**OS Parcel 5700 South West Of Grange Farm,  
Street Through Little Chesterton, Chesterton**

**23/02810/NMA**

**Proposal:** Amendments to the wording of condition 2 (proposed as non-material amendment to 22/01144/F)

Drawing Name:  
 Elevations

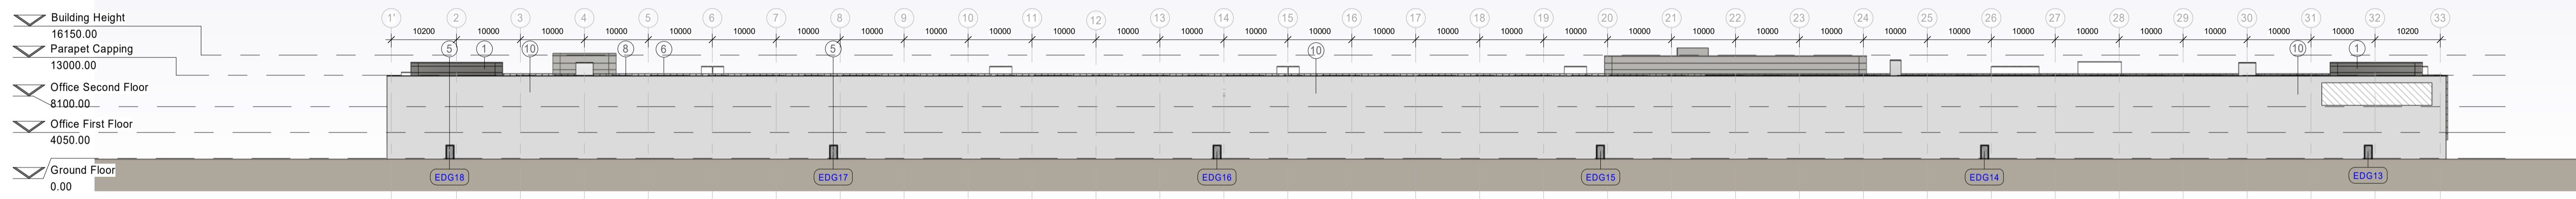
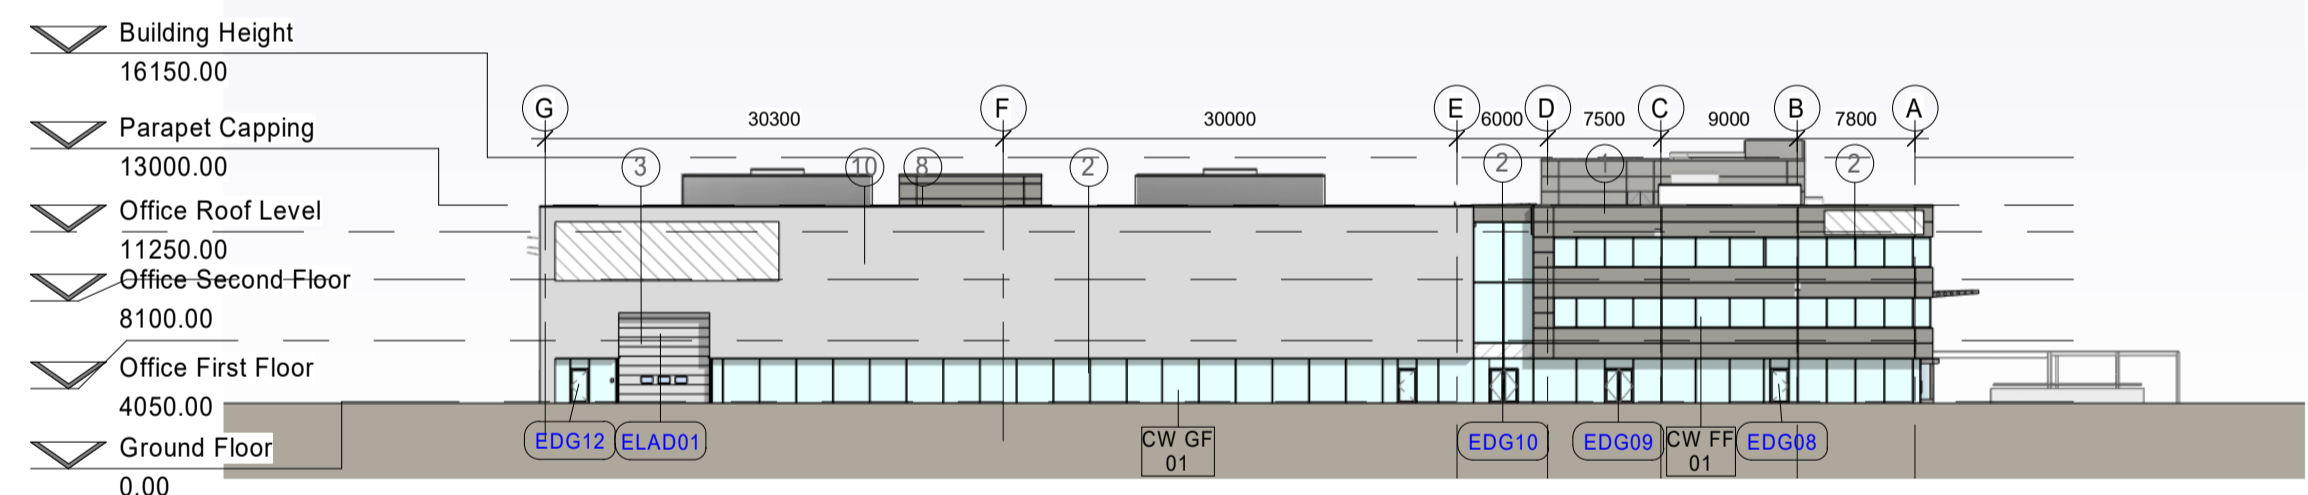
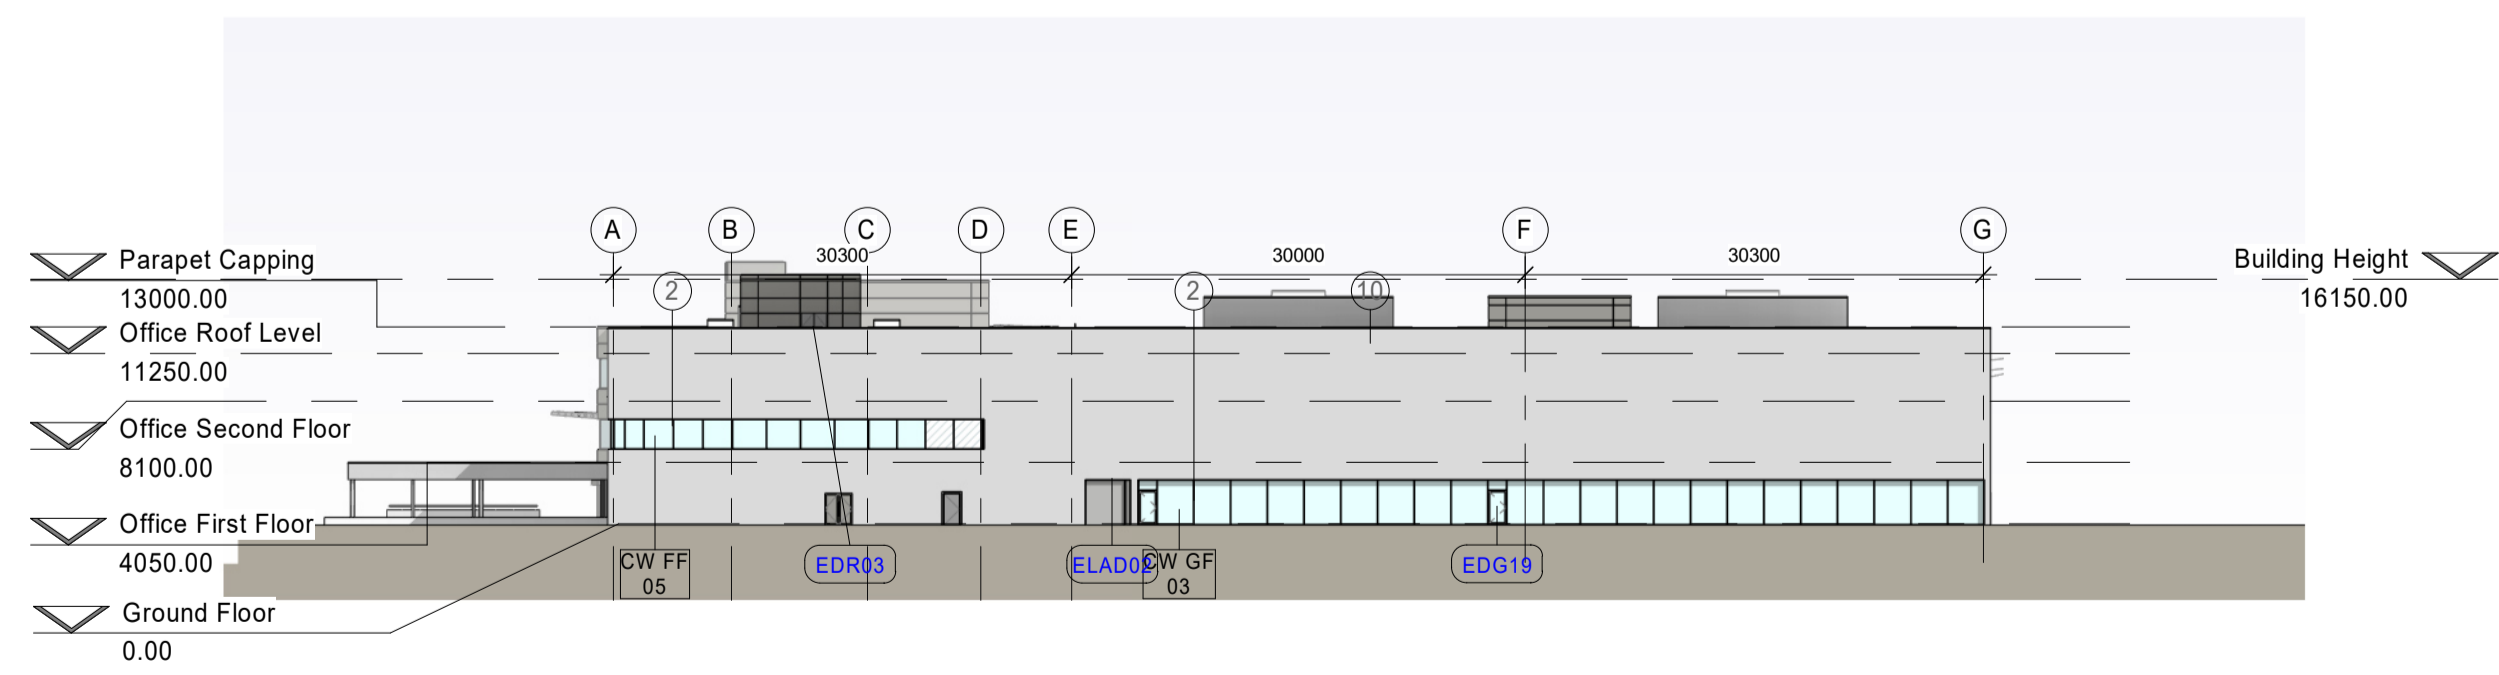
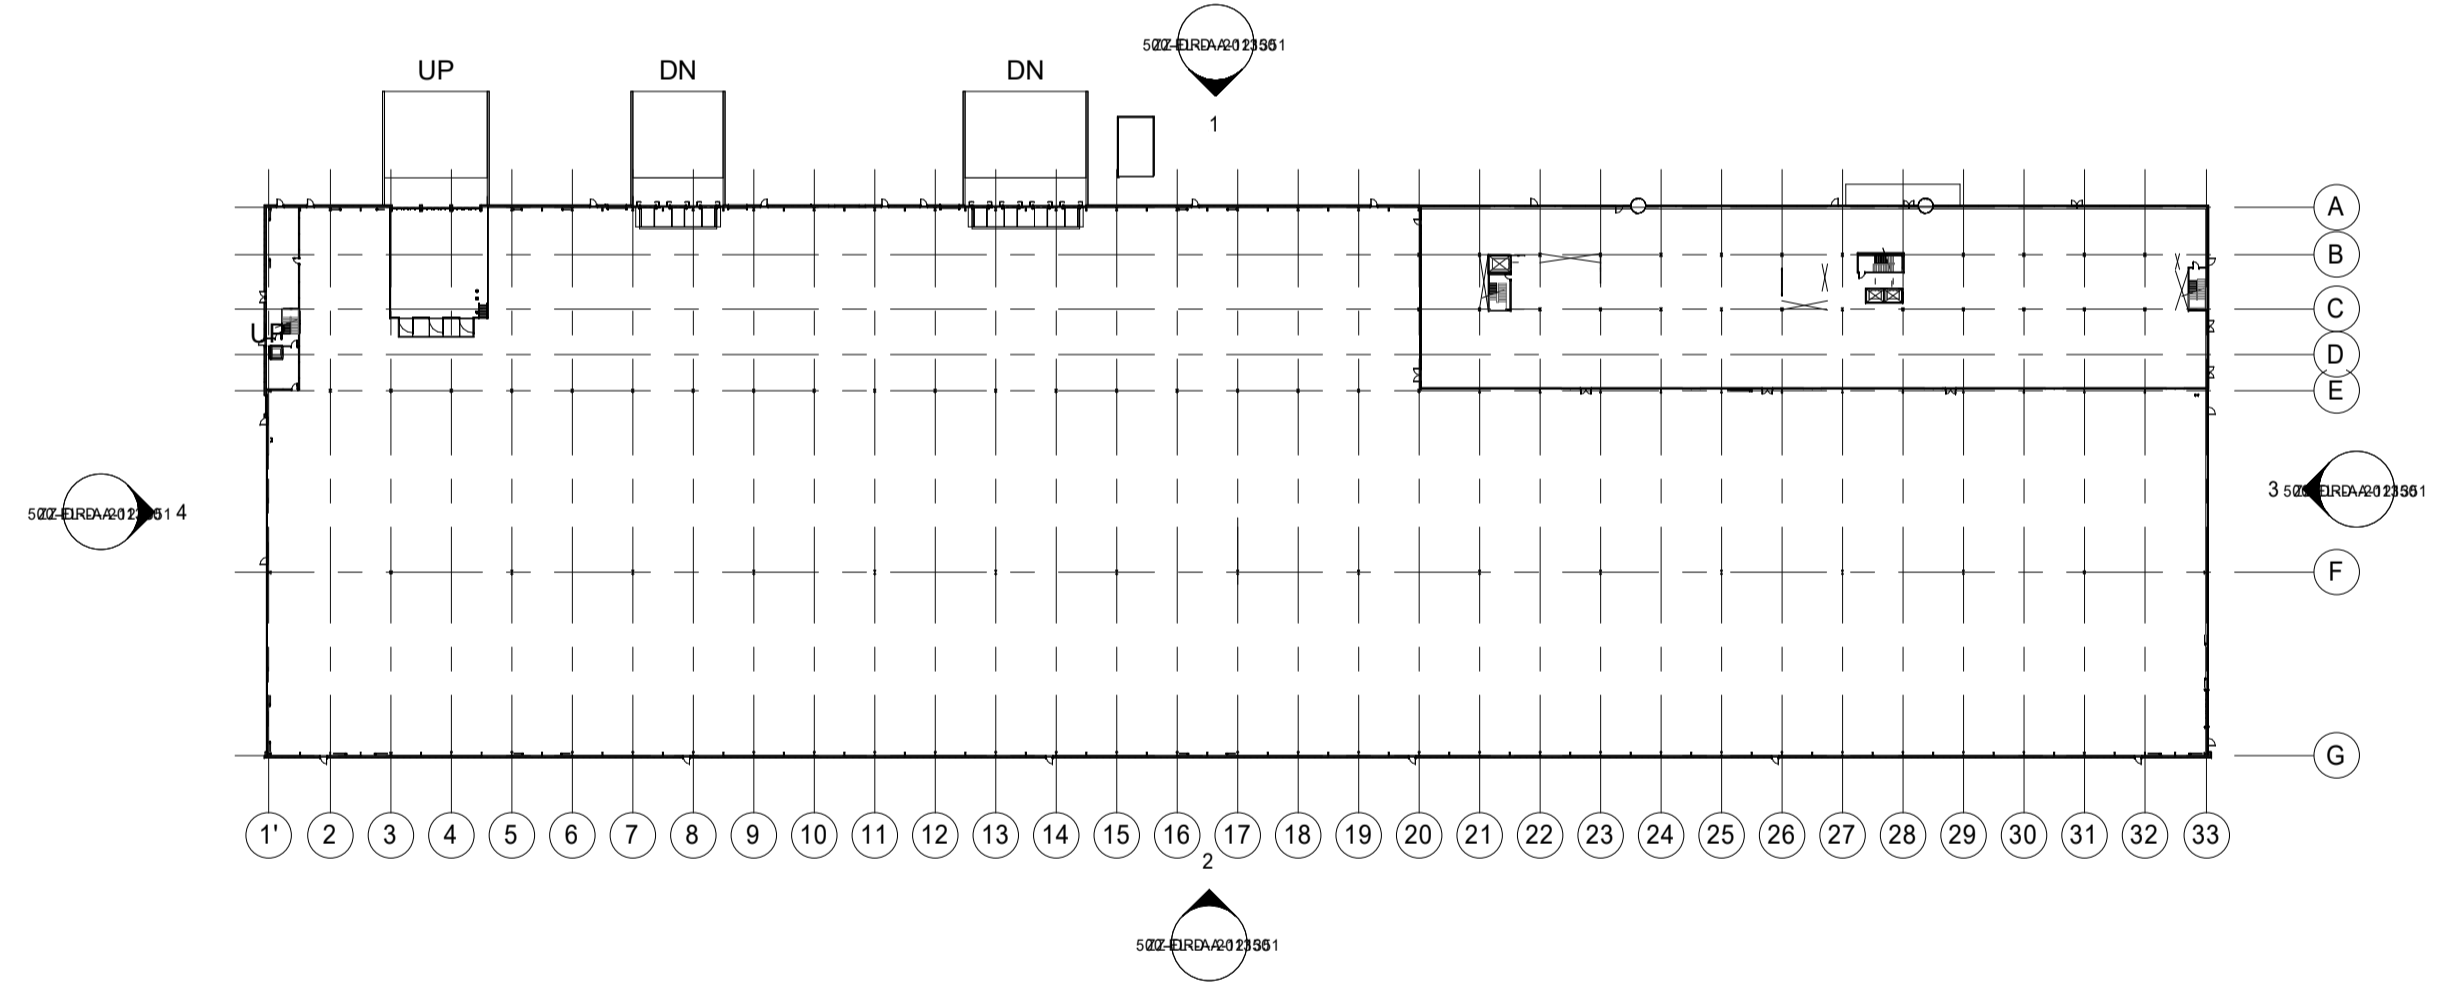
- Minor changes to the elevational details including:
  - NE Elevation: Replace built-up system with composite cladding panels; glazed windows added to second floor offices and Goods In office, relocation of 1 x revolving door and repositioning of doors/addition of roller doors;

- SW Elevation: 6 x external, personnel doors added;
  - SE Elevation: Repositioning of doors and addition of double doors;
  - NW Elevation: Repositioning of doors and addition of double doors.

- 5.4. The incorporation of a Welfare Block within the main building to allow the approved freestanding Facilities Management Building to be removed from the scheme, which would reduce the number of buildings on the site. The changes to the elevations, particularly when appraised in the context of the overall scale of this large commercial building, are all considered to be negligible and would not, even cumulatively, significantly or detrimentally affect the character and appearance of the approved building or the wider area.
